A47 Blofield to North Burlingham

Scheme Number: TR010040

Volume 8
8.13 Statement of Common Ground
with National Highways
and Blofield Parish Council

Statement of Common Ground – Blofield Parish Council

SUITABLE FOR INFORMATION

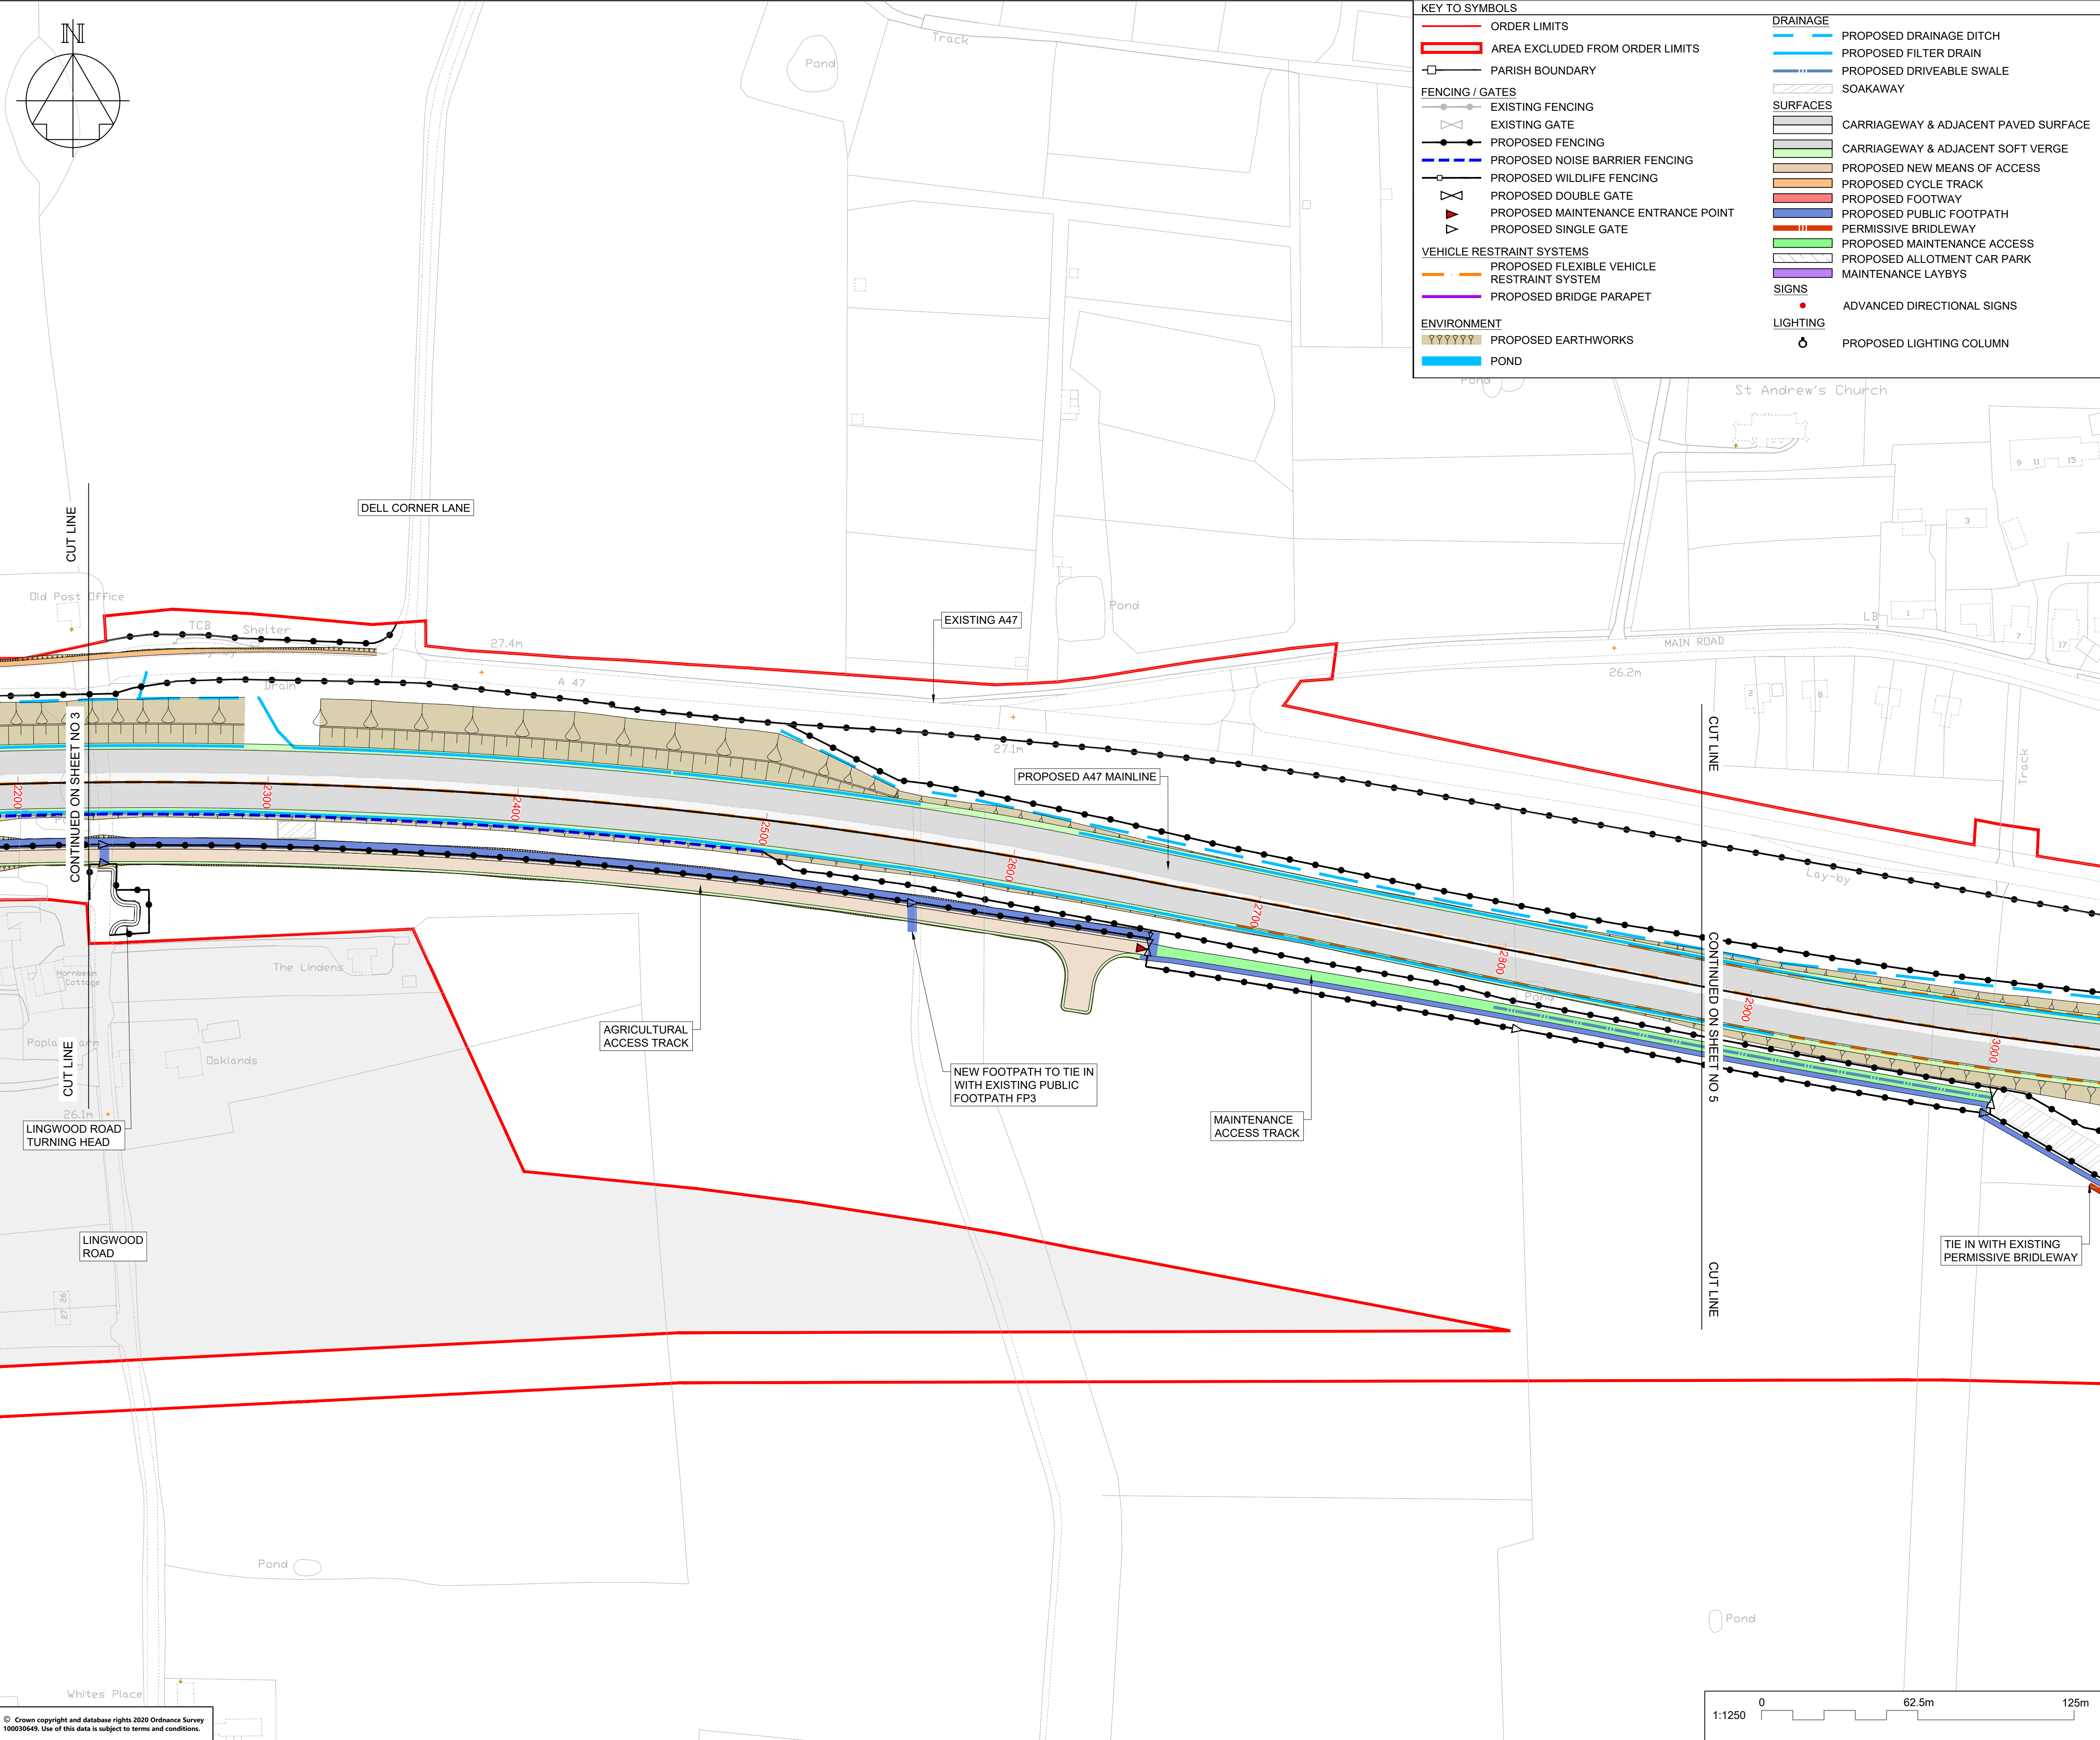
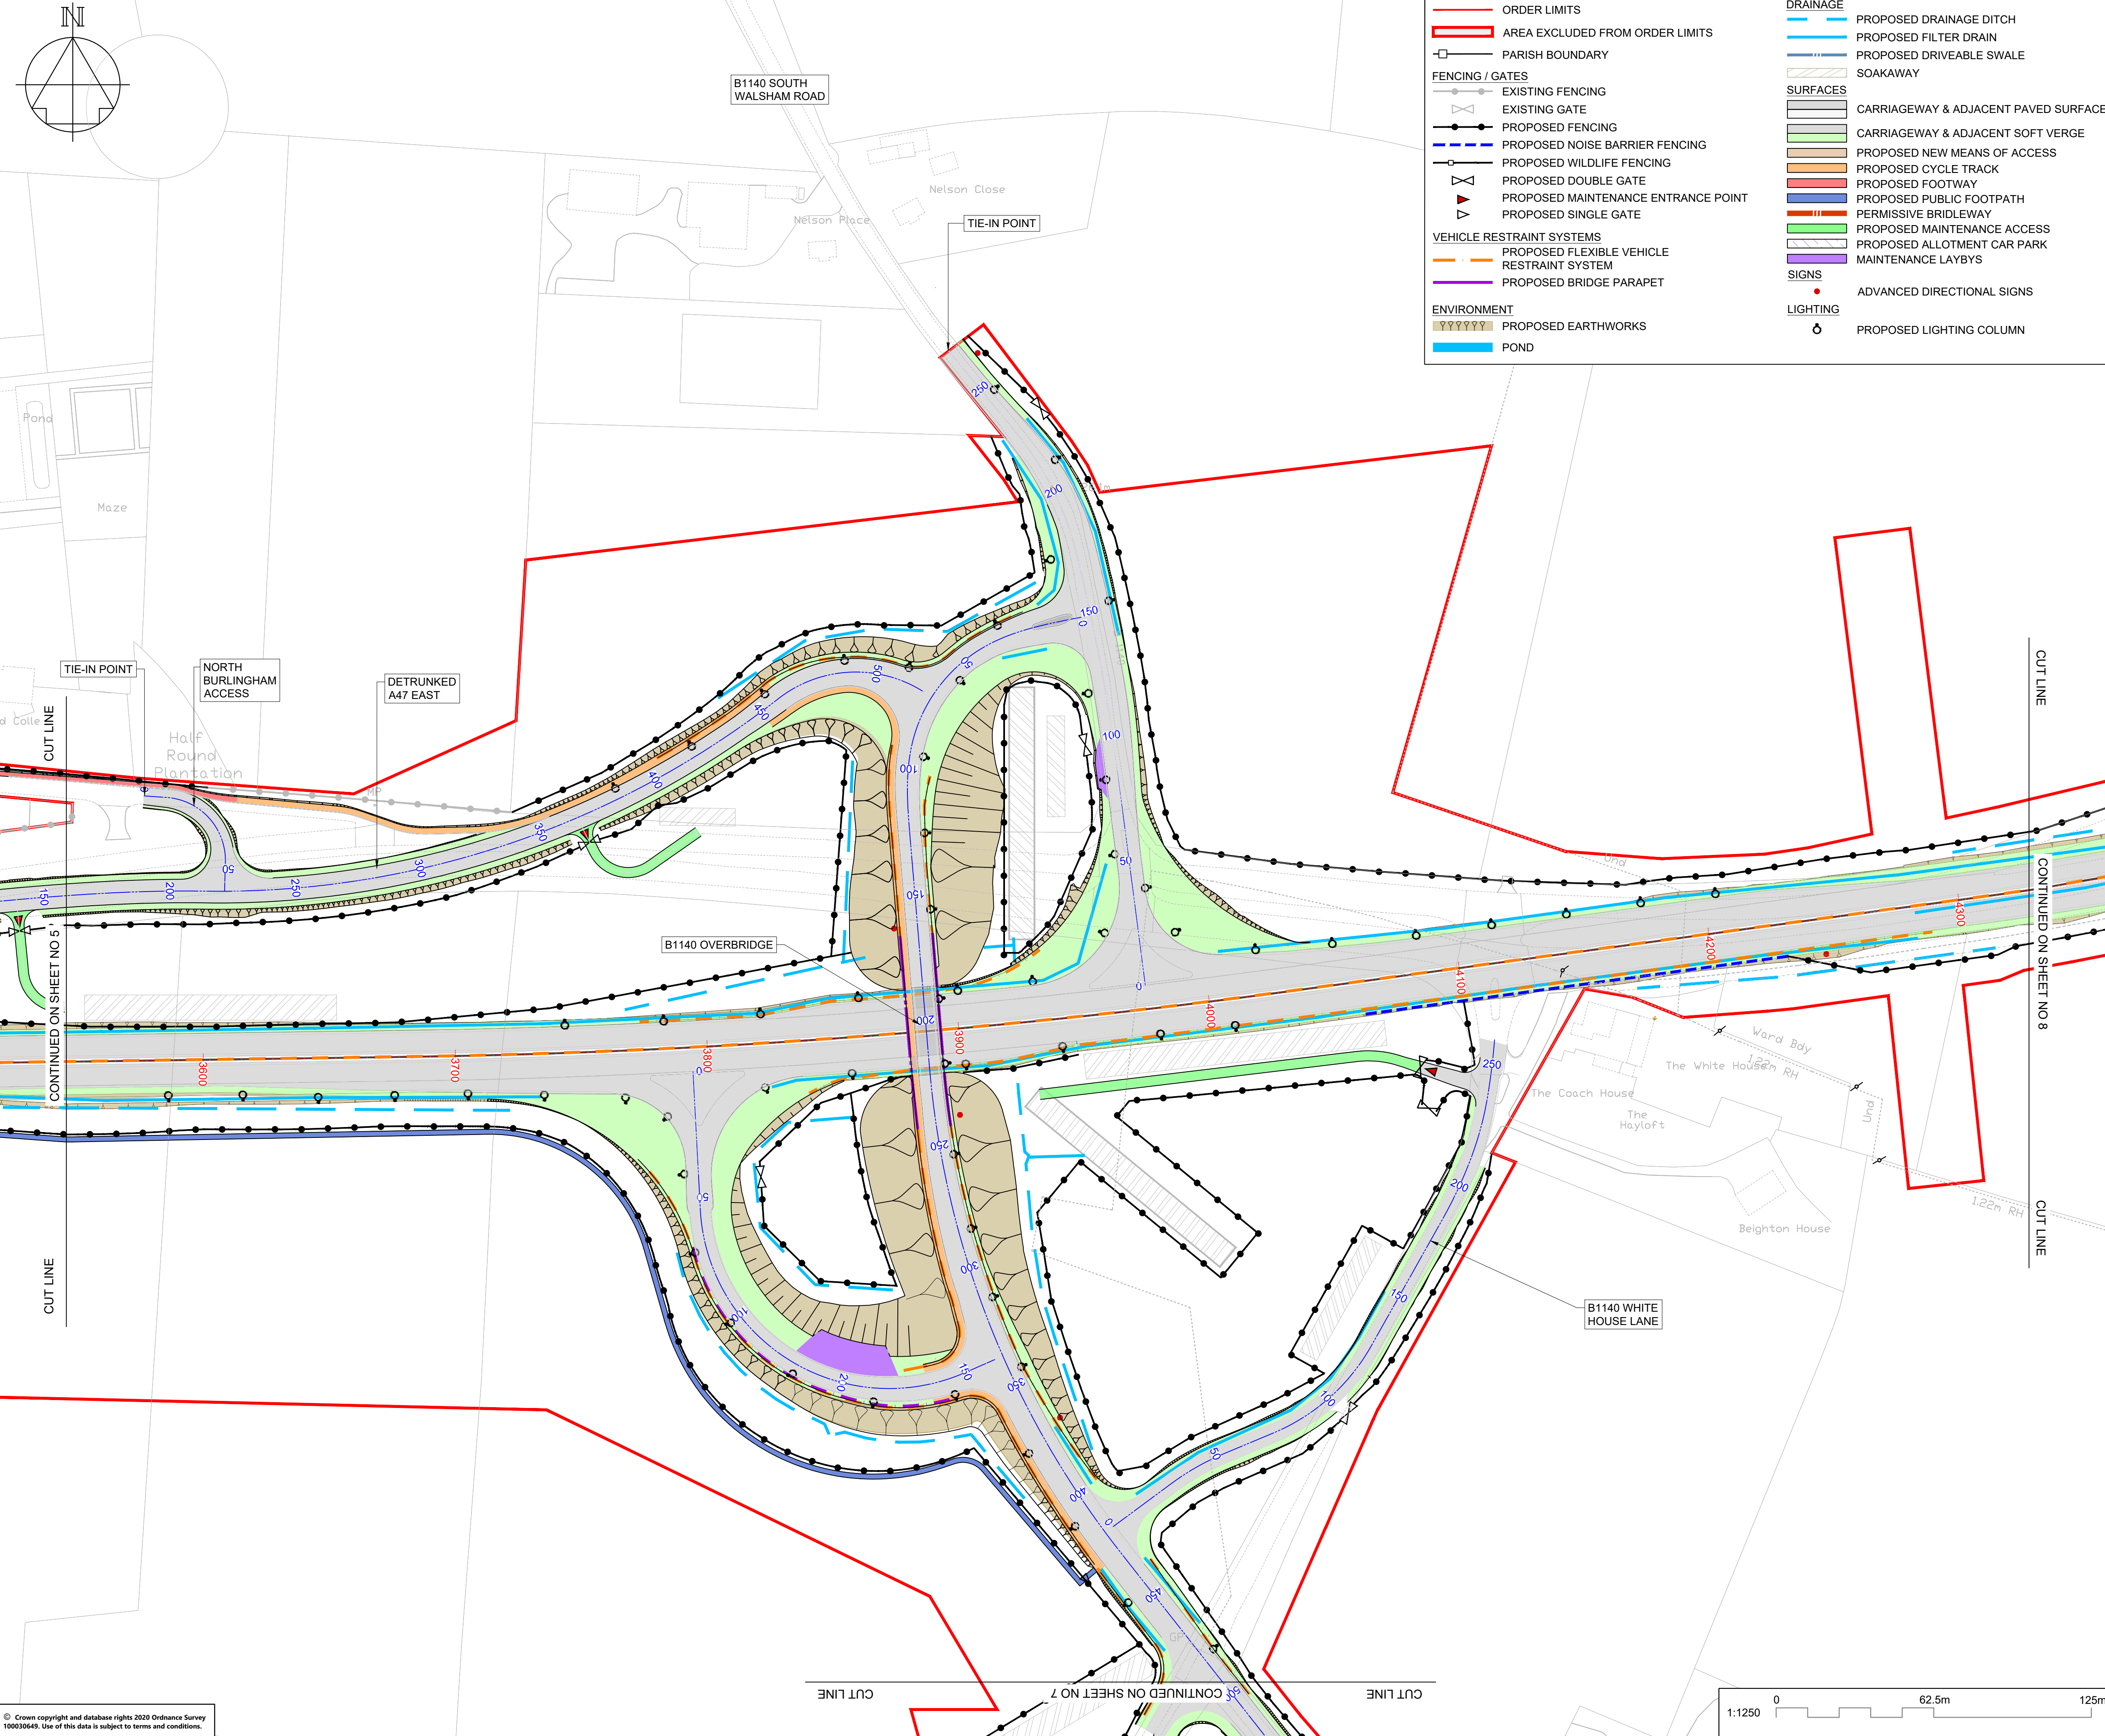
Road Lighting	Letter from BPC in Appendix C, Appendix H & Appendix I	2.6 General Arrangement Plans The proposed 20 lighting columns would be in contradiction of the Blofield Neighbourhood Plan Environment 5 Policy regarding Dark Skies. If the proposed junction was amended as per our suggestion at the beginning of this document, then the junction lighting would not be in contradiction to our local plan policy.	As described in the Scheme Design Report (REP1-046) lighting is proposed at the Yarmouth Road as road safety mitigation. The lighting will be LED and include back shields, where appropriate, to limit light spill. The modified junction arrangement as proposed by Blofield Parish Council is not a technically viable solution. Whilst Option B, considered in the Scheme Design Report (REP1-046) may not require lighting, it would have other environmental impacts resulting from the increased land take and additional construction.	Under discussion

Issue	Document Reference	Blofield Parish Council Comment	Applicant's Response	Status	Date
			The provision and assessment of lighting in the ES Chapter 7 (APP-045) and the Lighting Assessment contained in Appendix 7.8 (APP-085) assume the worst-case scenario and if alternative solutions can be found to improve the visibility of the junction without the need for lighting the lighting may be removed during detailed design.		
Road Lighting	Email from BPC in Appendix E	There are also a lot of street lighting columns which is against the dark skies policy of the council.	See response above regarding street lighting.	Agreed	11-Nov-21
Hedgerows	Letter from BPC in Appendix C	2.9 Hedgerow Plans The Council is disappointed that there appears to be limited new hedging being planted to offset the hedging being removed.	The hedgerows to be provided are shown on the Masterplan (REP7-011). The scheme results in a biodiversity net gain of greater than 40%.	Agreed	11-Nov-21
